Able - Proposed MEP, Killingholme

Associated British Ports (10015525)

**Representations in relation to Supplementary Environmental Information and Applicant's
Comments on Written Representations**

Hydrodynamics and Sedimentation

Figure 17 Model layout and bathymetry with earlier arrangement of AMEP scheme (Layout 1b) used for the assessment of longer term changes to morphology

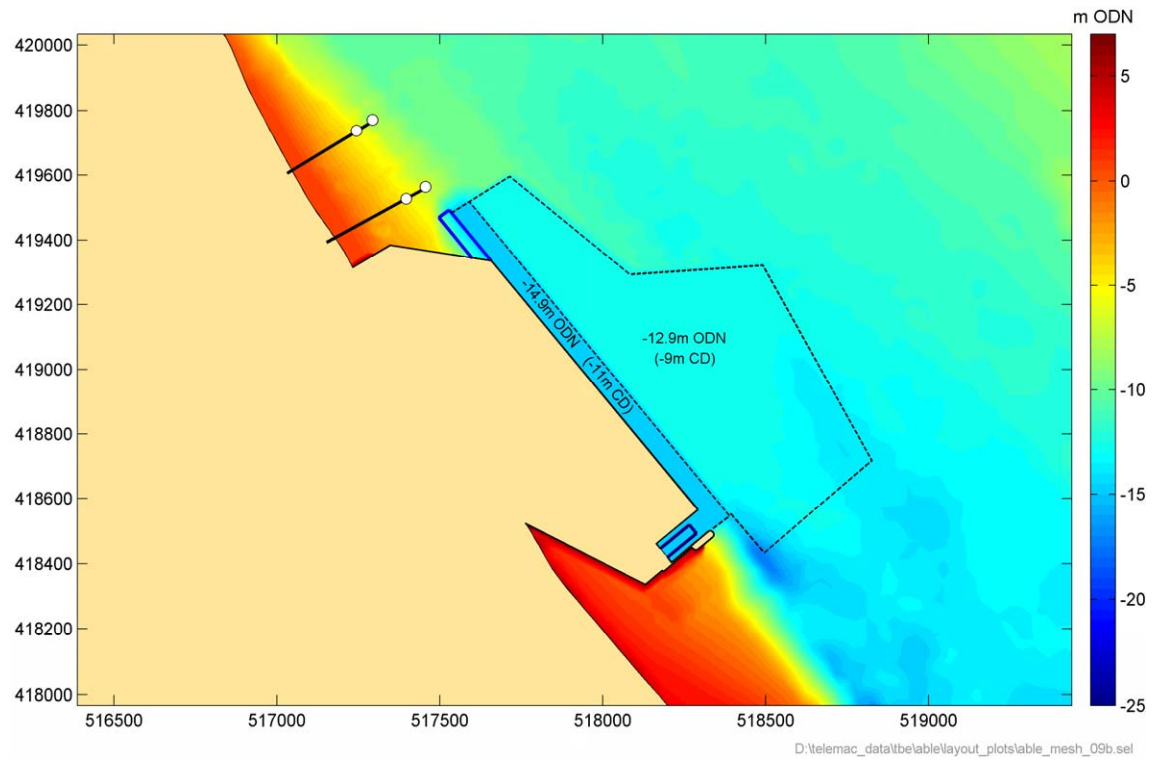
- IV. Section 3.3.2 states that the large circulation zone (in the vicinity of the CPK jetty (HST/C.RO in our documents)) predicted in the original ES modelling has now disappeared due to the set back of the face of the reclamation. This is not the whole reason as the flow regime shown in the original ES is **considered to be in error, as it shows an unrealistic flow direction immediately up estuary of the reclamation** (Figure 17 in the ES report). The new

modelling indicates a more realistic flow regime with an eddy immediately up estuary of the reclamation. **This comparison suggests there was some error in the original hydrodynamic modelling around the development, therefore those results were unreliable;**
